**Town & Country Planning Act 1990 (as amended)
Town and Country Planning (Development Management Procedure) (England) Order 2015
Application for Planning Permission**

Development Demolition of existing dwelling & erection of a 62 bedroom care home (C2 Residential Institution) with car park, landscaped gardens & access from Roundstone Lane (resubmission following A/51/18/PL). This application is a Departure from the Development Plan.

Location Pound Place Roundstone Lane Angmering

Client	Hallmark Care Homes		
Project	Proposed Care Home Pound Place Roundstone Lane Angmering		
Drawing	Structure to Front Parking Bays Plan & Elevations		
Date	Dec. 2018	Scale	1:100 @ A1
Drawn by	RAC	Drawing No	1388/010
Checked by	-		A
Status	Planning

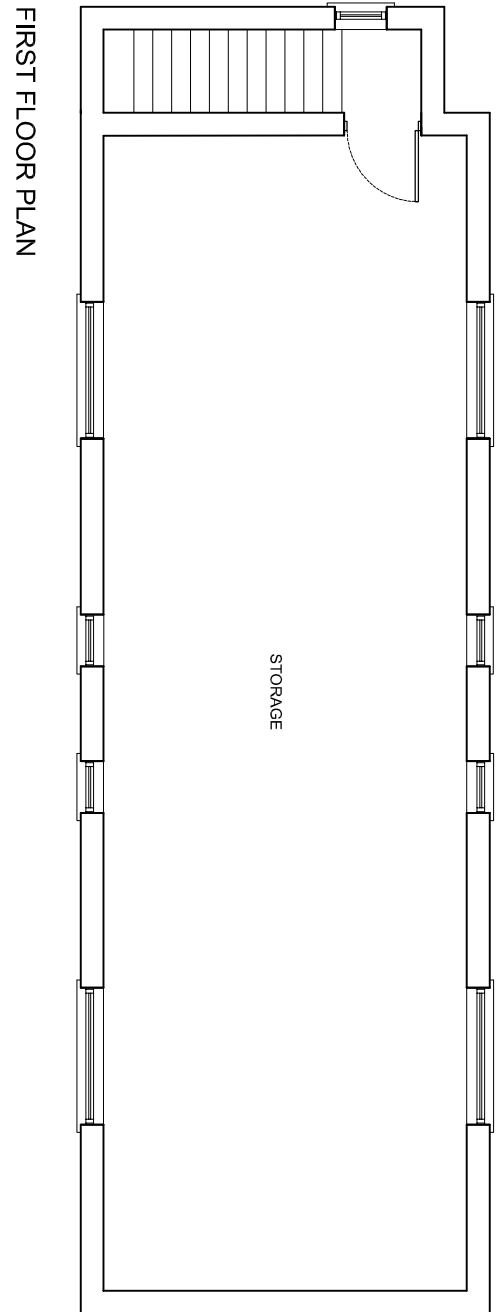
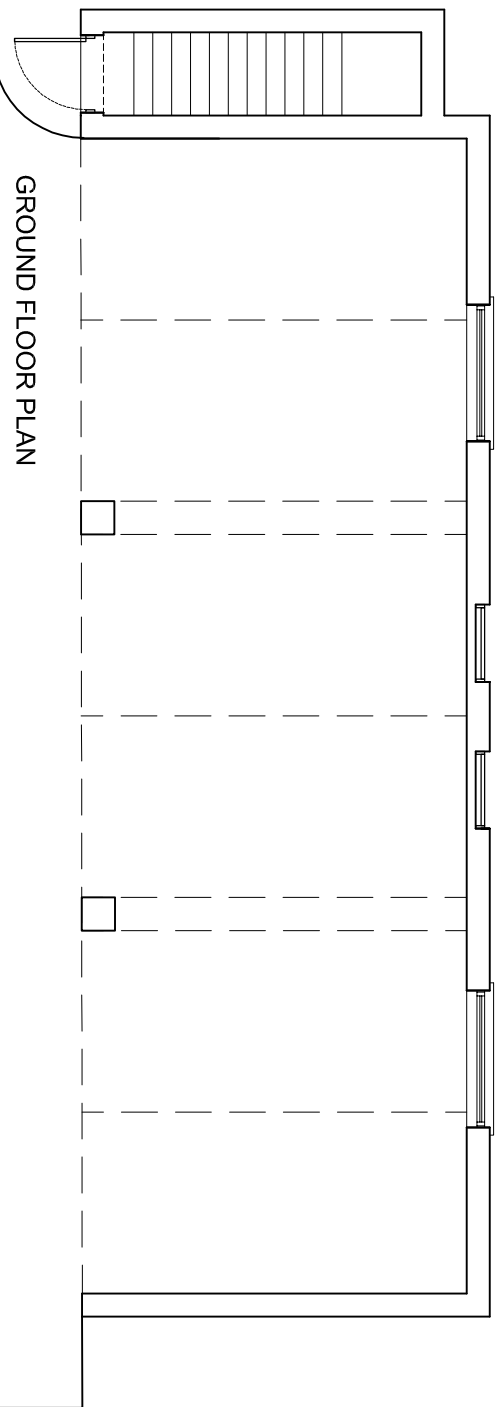
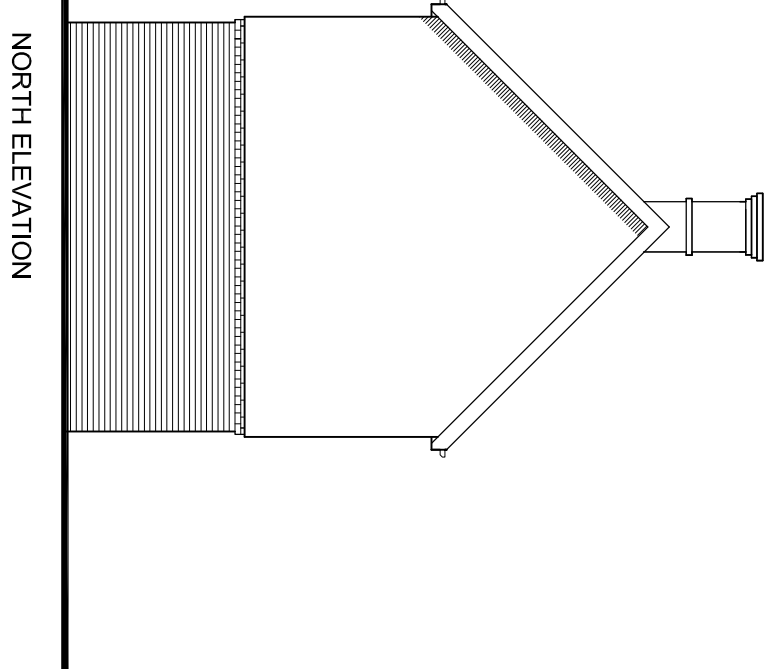
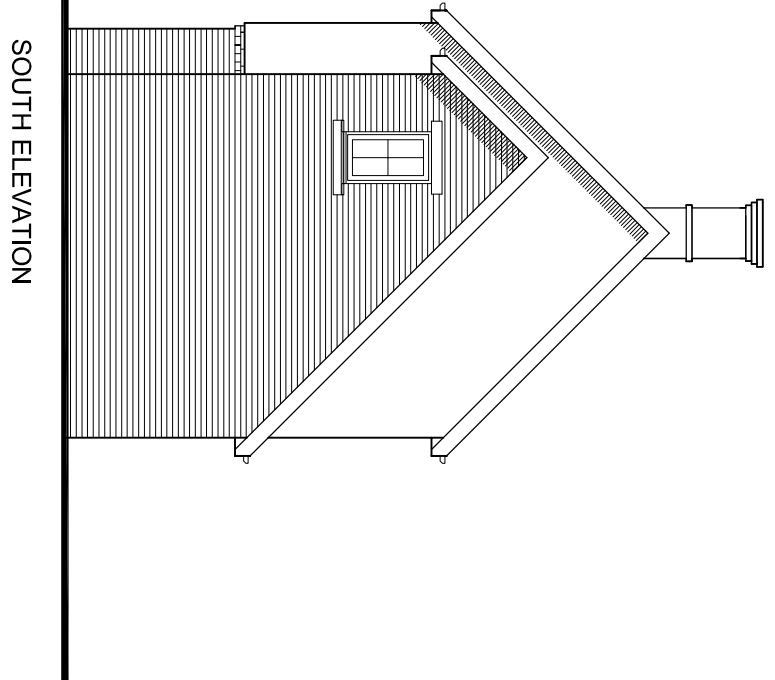
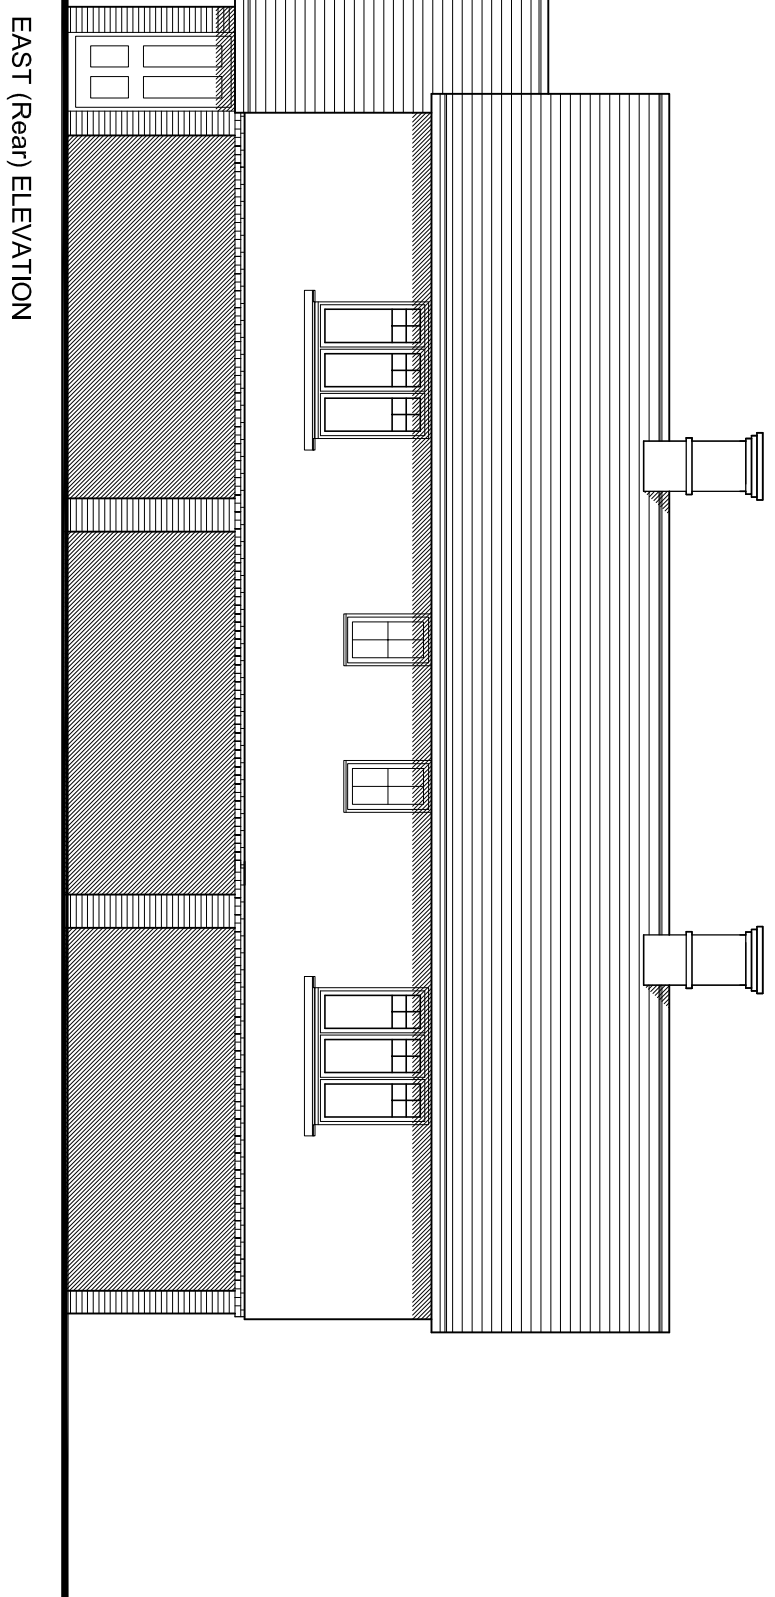
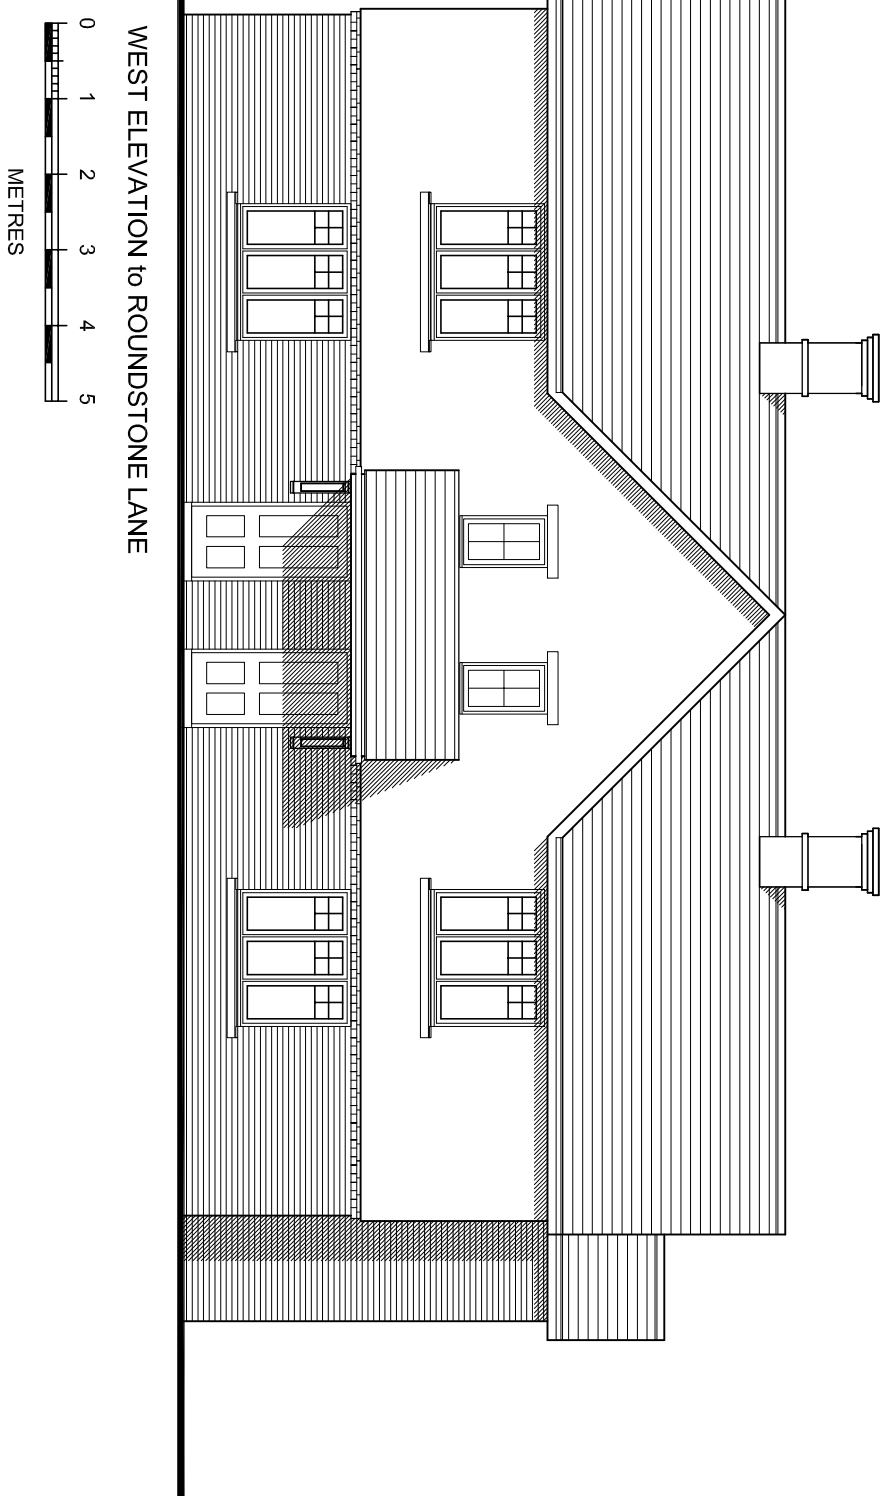
The first floor plan and south elevation of the structures to front of parking bays don't accord. Please amend accordingly.
